Jeanie Bourke - RE: Inn at Diamond Cove - Railings

From: Jeanie Bourke
To: Chris Pirone; Kevin Gough
Date: 8/19/2014 10:49 AM
Subject: RE: Inn at Diamond Cove - Railings
CC: Craig Messinger; David Lloyd; Laurie Leader

- *The exterior balconies, deck, and stair pipe rail design is not approved with the issuance of this permit. Alternative designs shall be submitted for approval for code compliant opening limitations and height prior to the fabrication of said rails.*

**PORCH SECTIONS**  
**A3.11**

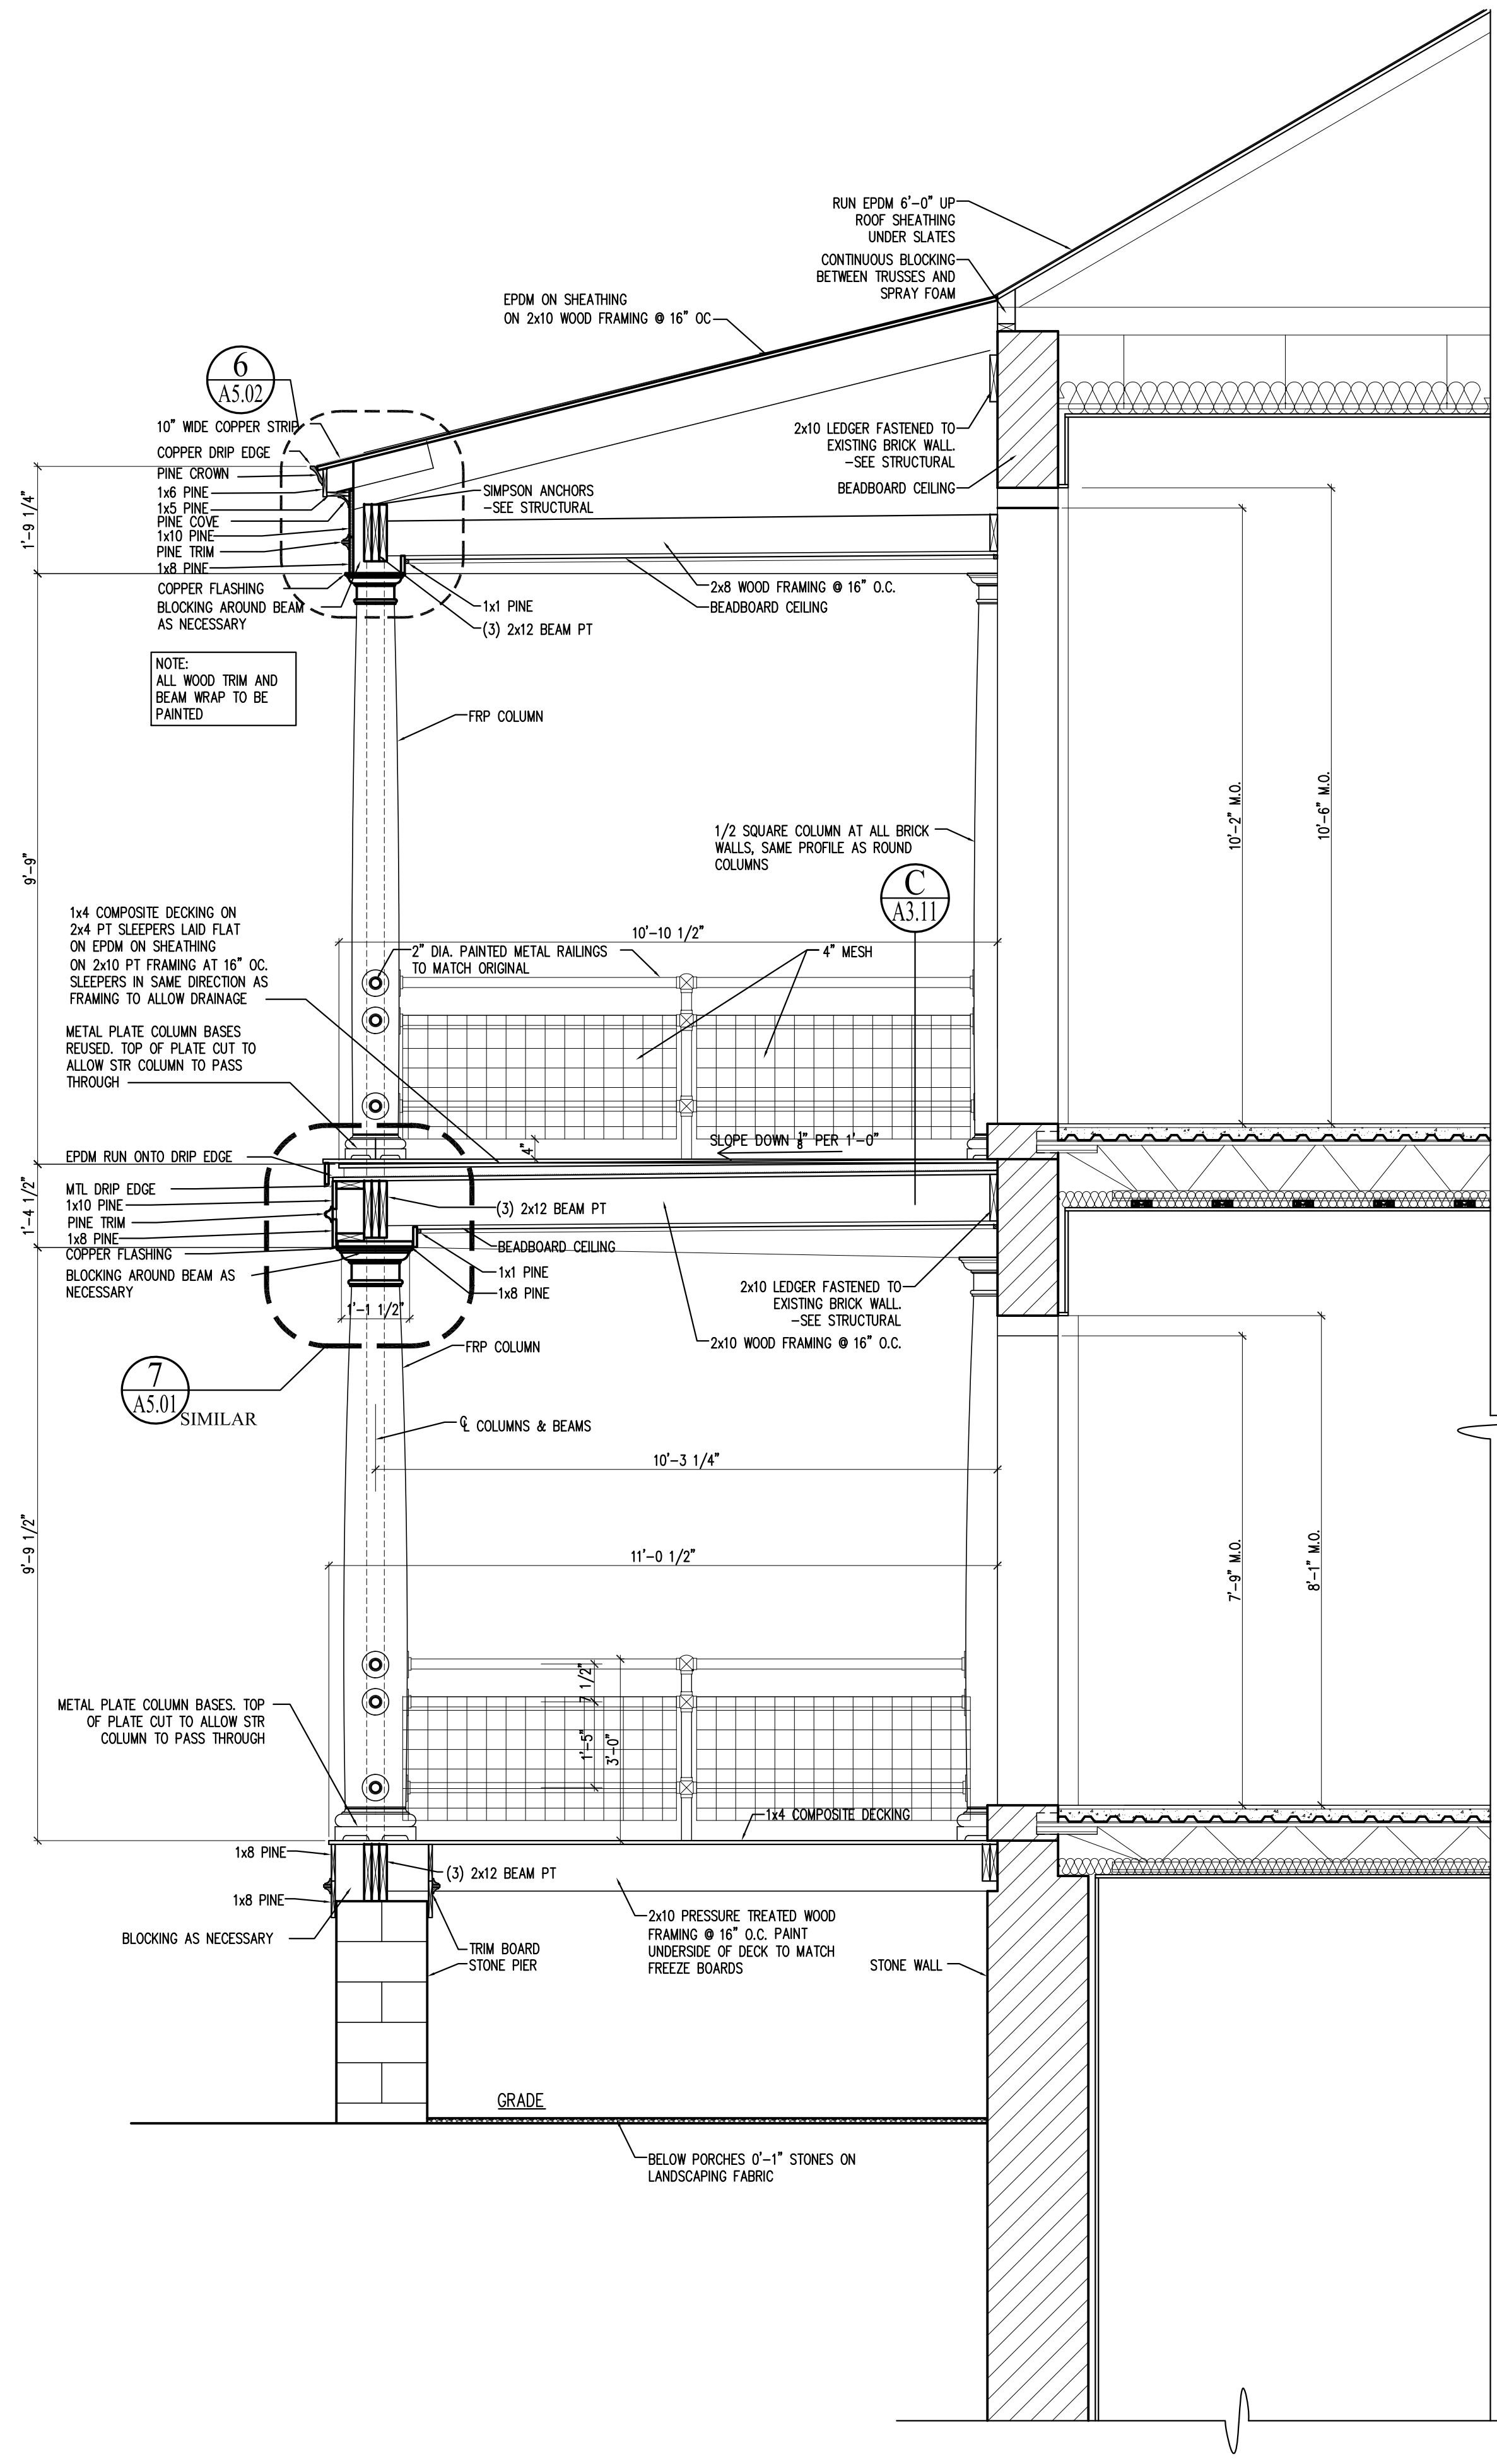
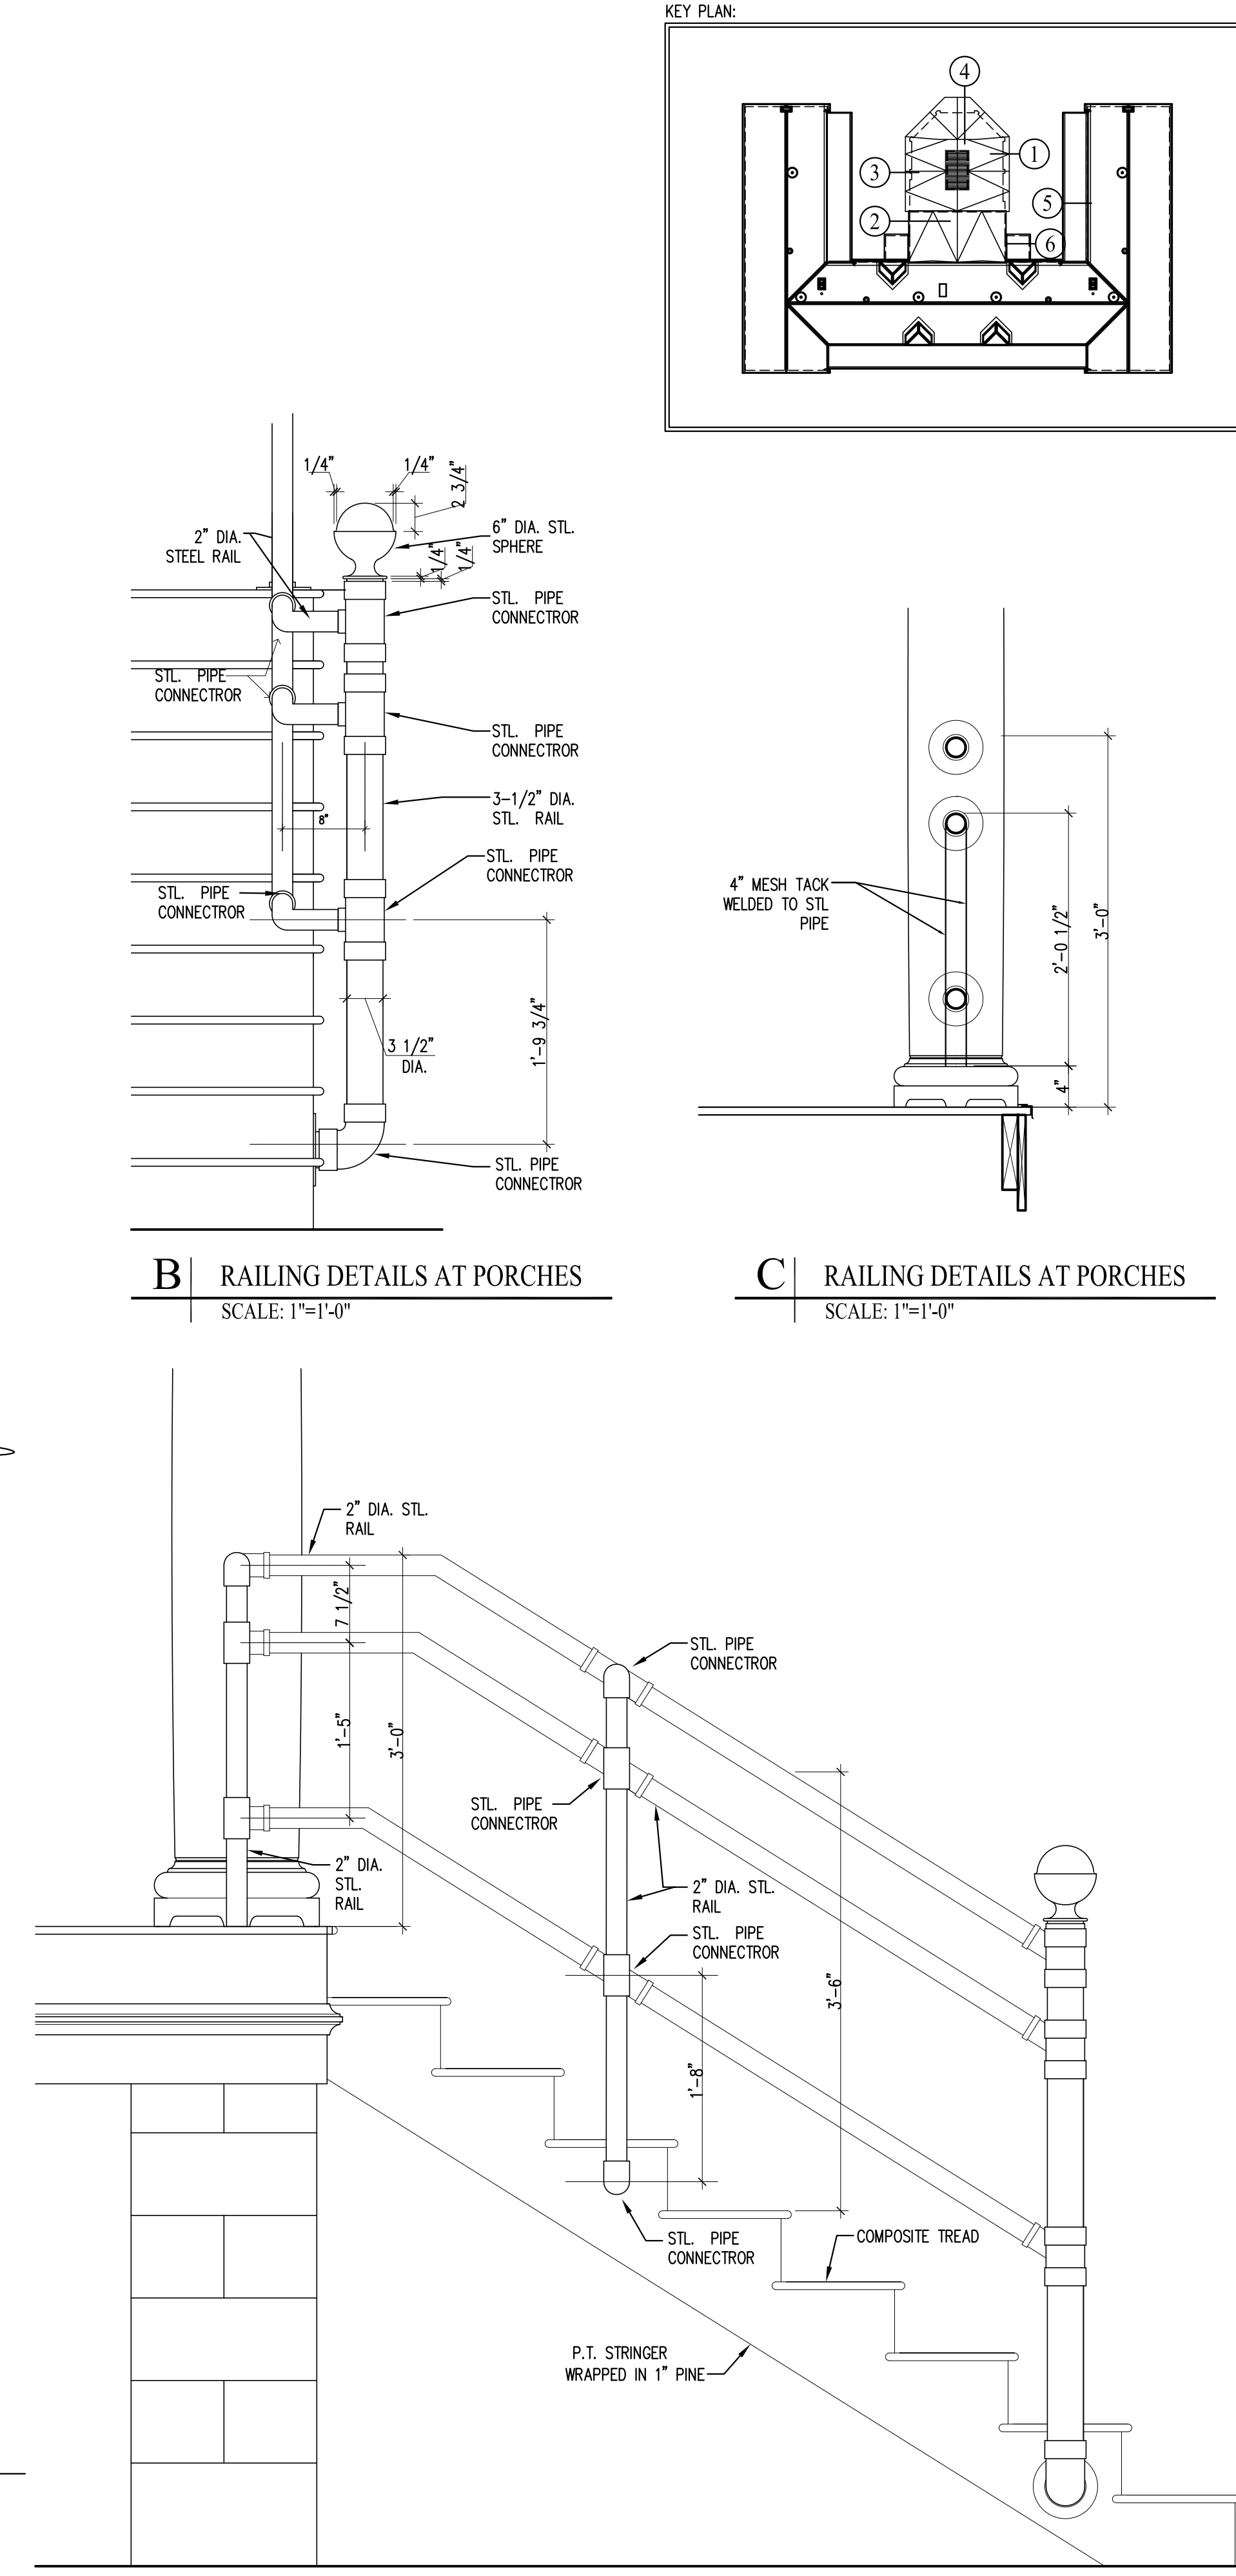
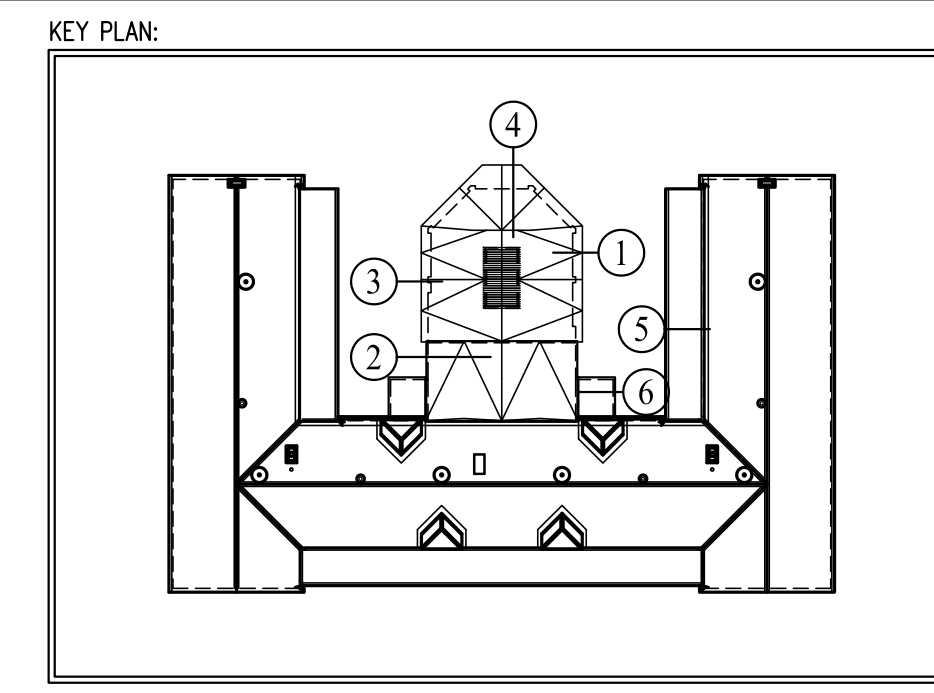
1. The mesh/netting detail is not consistently shown. It is on the upper decks, but not on the lower.
2. Will this be wire or rope? Detail C Rail Netting Detail shows netting with zip ties while the other C Railing Detail at Porches shows 4" mesh tack welded to steel pipe. The rope detail with zip ties is not a permanent solution.
3. What about adding the mesh to the stair rail to the from the stair stringer to the top of the 2nd rail for fall protection?

1. You state below "the top of the railing on the stairs will be at 36 inches to be used as a handrail". So is the 3'-6" dimension on the drawing incorrect? Circled in red is the 2nd pipe down at 36", please clarify.
2. Are you proposing the mesh to be installed down the stair rail as well? While this is more in compliance, will the mesh impact the space for graspability of the hand rail?

1. For complete fall protection of the guardrail on the porch railing system, the wire mesh should continue the full height of the 36" rail. While not up to new construction standards, it should provide a safe fall protection solution, within the Historic Building provisions of the IBC.
2. The stair rail design does not incorporate the reduction in openings provided by the wire mesh. It also does not appear to provide handrails at the required height and extension. Can you please look into an alternate proposal that is acceptable for both historic and life safety elements.

The intention is to go ahead and use the welded wire mesh (we have changed it to 3" mesh to eliminate any issue with the 4" sphere) which will be tack welded to the railings. The top rails will all be at 3 feet above the deck and above the stairs.

I have also included the wire mesh on the stair railing, but I have not shown it going all the way down to the stringer as you suggested. The reason is that there is nothing to which to attach that bottom edge, and this will be the cut edge of the wire mesh. If that is loose, but attached at the next rail up, then someone could get their foot stuck between the mesh and the stair. Not a good situation.

In response to your email from last week, yes, the original drawing incorrectly noted the railing on the stairs as 3'-6". That railing, like all of the other rails on the porches, will be at 36".
The mesh we are using will only be installed on the porch rails because of the difficulty of meeting the graspability requirements for the top rail.

When the permit was amended this past spring, the attached sheet A3.11 was included with a modification to the guardrails which addresses the openings of the railing with welded wire mesh, but our understanding was that the height was not required to be modified due to the historic restrictions on the project, the fact that the railings were intact (prior to the fire) and thus were preserved historic fabric, and the same railing is used consistently throughout the site on the adjacent buildings and historic needs us to keep the consistent character.
